From: Laura Gibbons <Laura.Gibbons@arun.gov.uk>
Sent: 10 August 2021 14:05
To: Planning.Responses <Planning.Responses@arun.gov.uk>
Cc: Simon Davis <Simon.Davis@arun.gov.uk>
Subject: RE: Planning Re-Consultation on: BN/98/21/DOC

Engineers Comments Regarding Condition 10

Application No: BN/98/21/DOC

Site Address: Land North of 1 Northfields Cottages Fontwell Avenue Eastergate PO20 3RX
Grid Reference: 494714 106230
Category: Discharge of Condi
Description of Works: Approval of details reserved by condition imposed under BN/50/20/PL relating to conditions

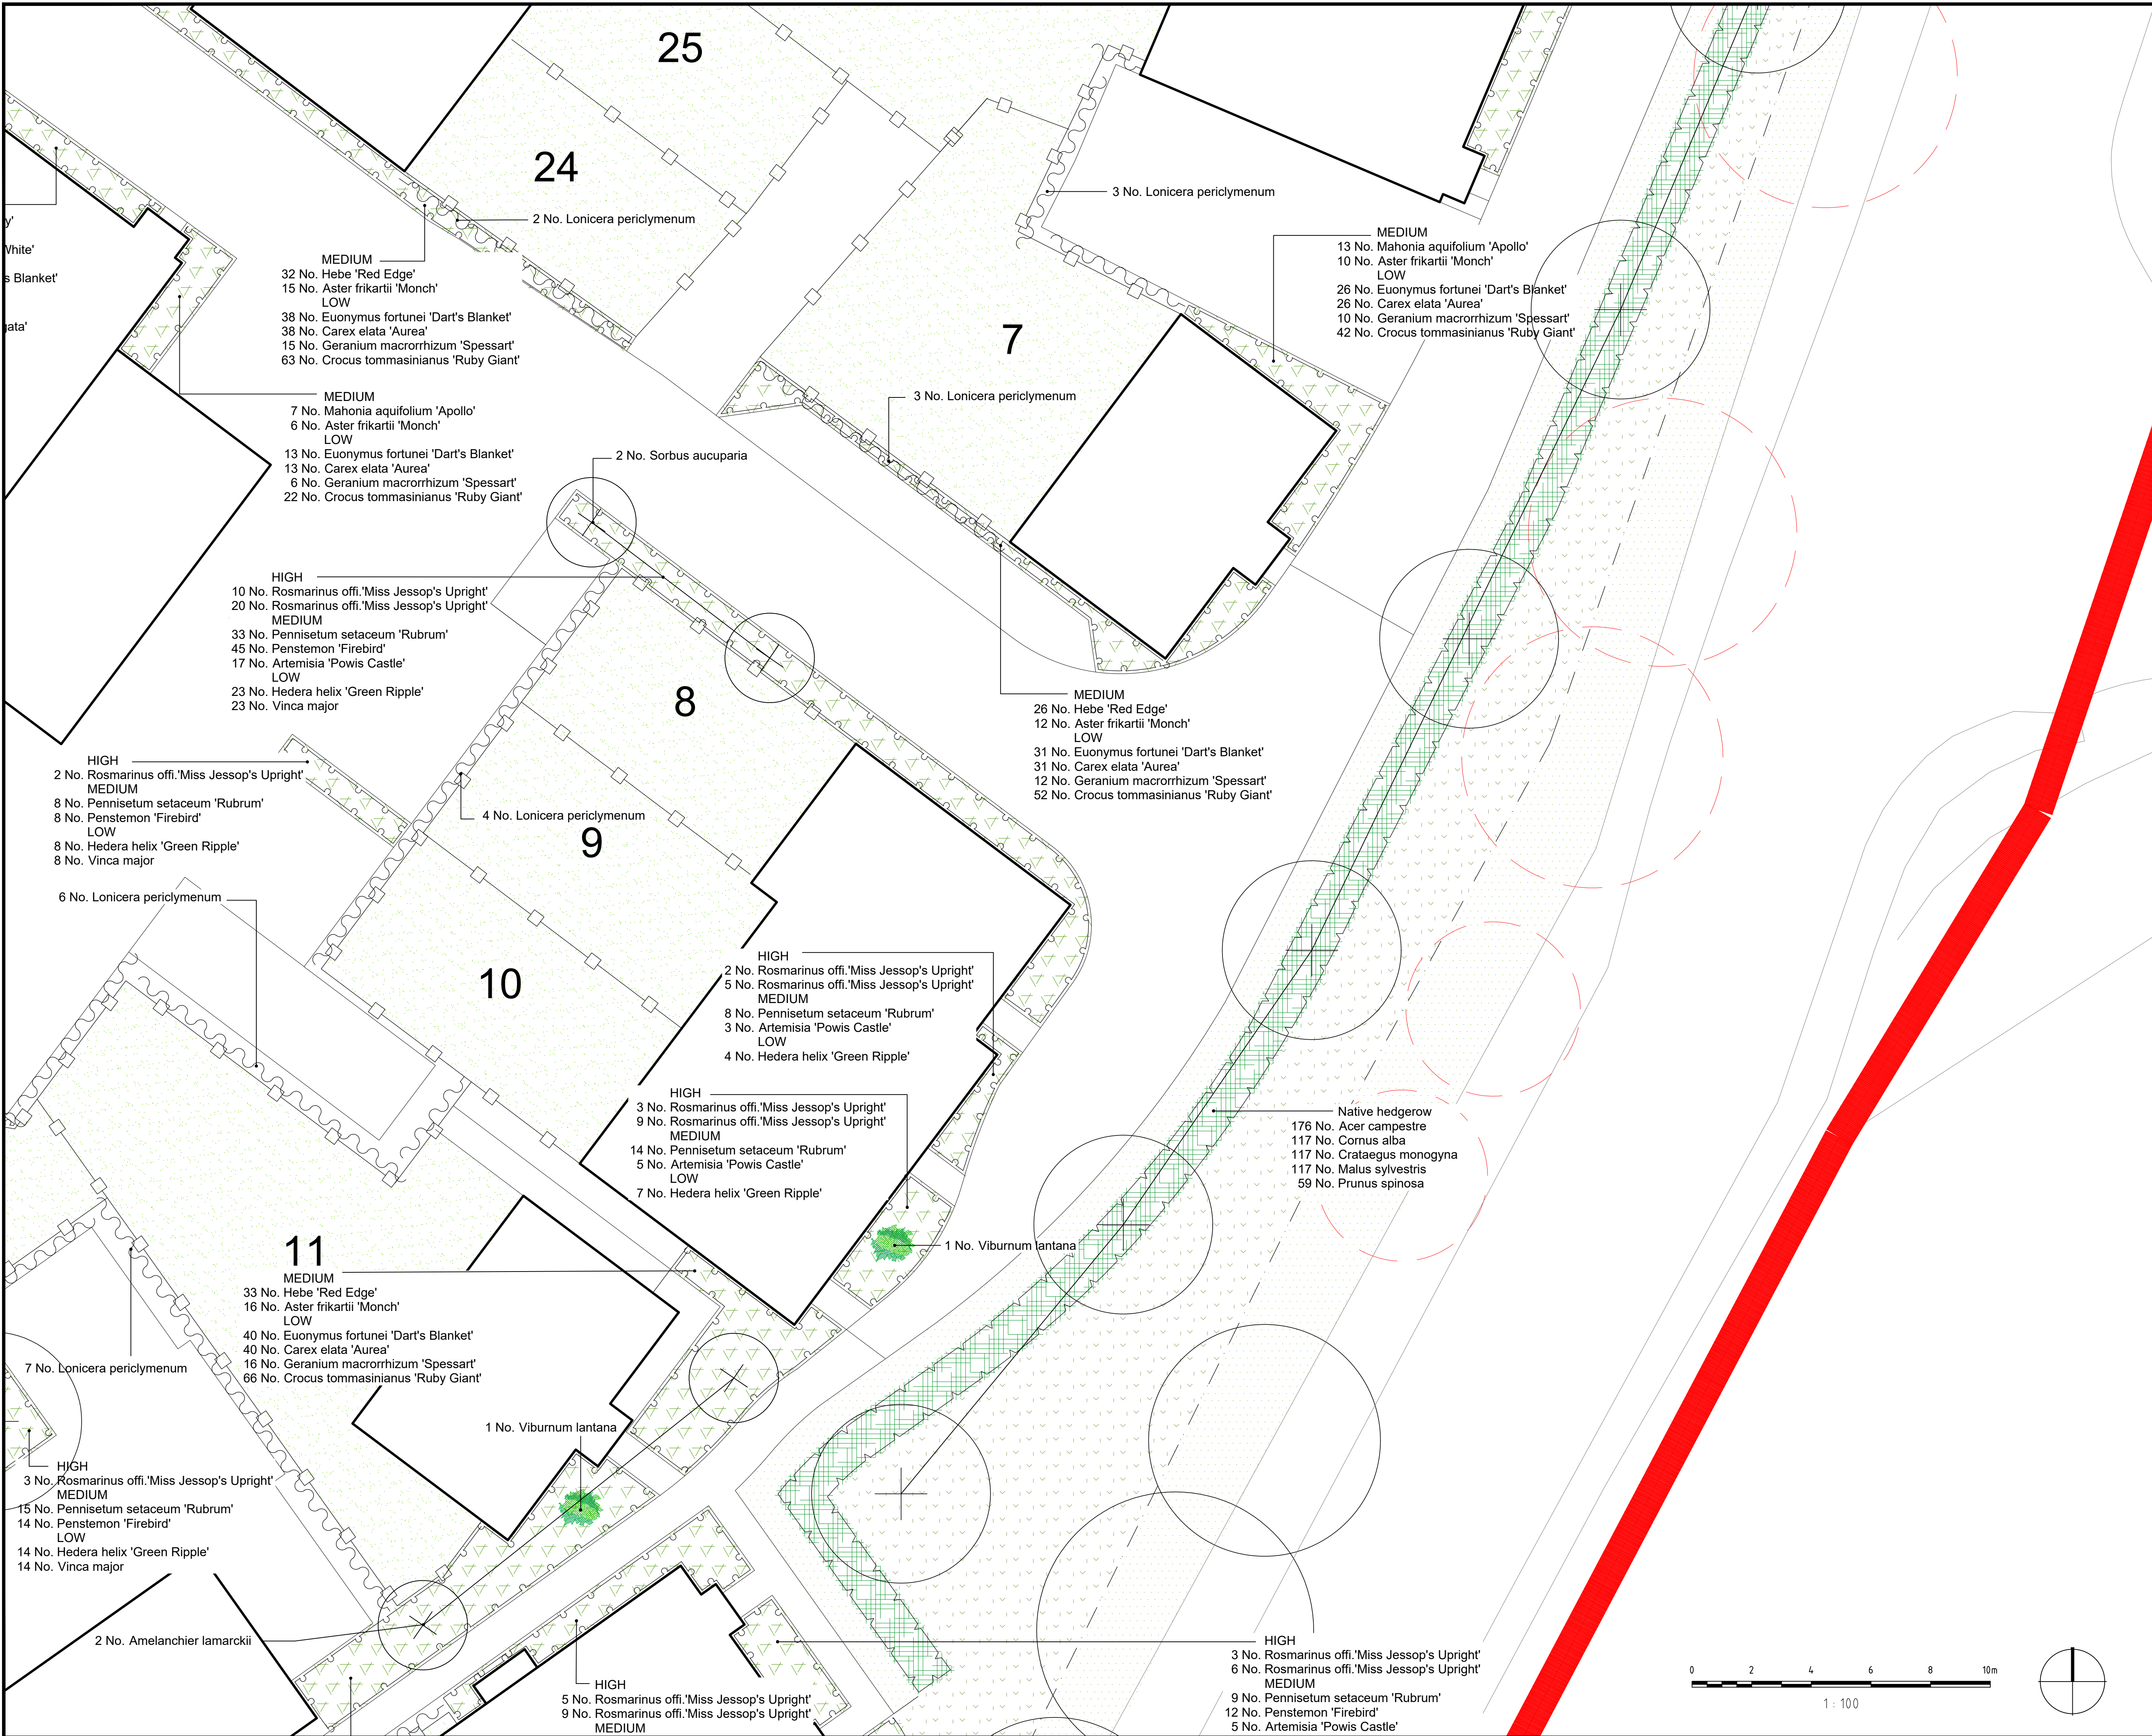
- The drainage layout needs to be more detailed, i.e. include details of the pipe networks e.g. pipe diameters, falls, manhole cover and invert levels, catchpits, etc.
- There is significant conflict between the proposed landscaping plans and the proposed drainage. This must be resolved so that trees are not proposed over pipes or crates.
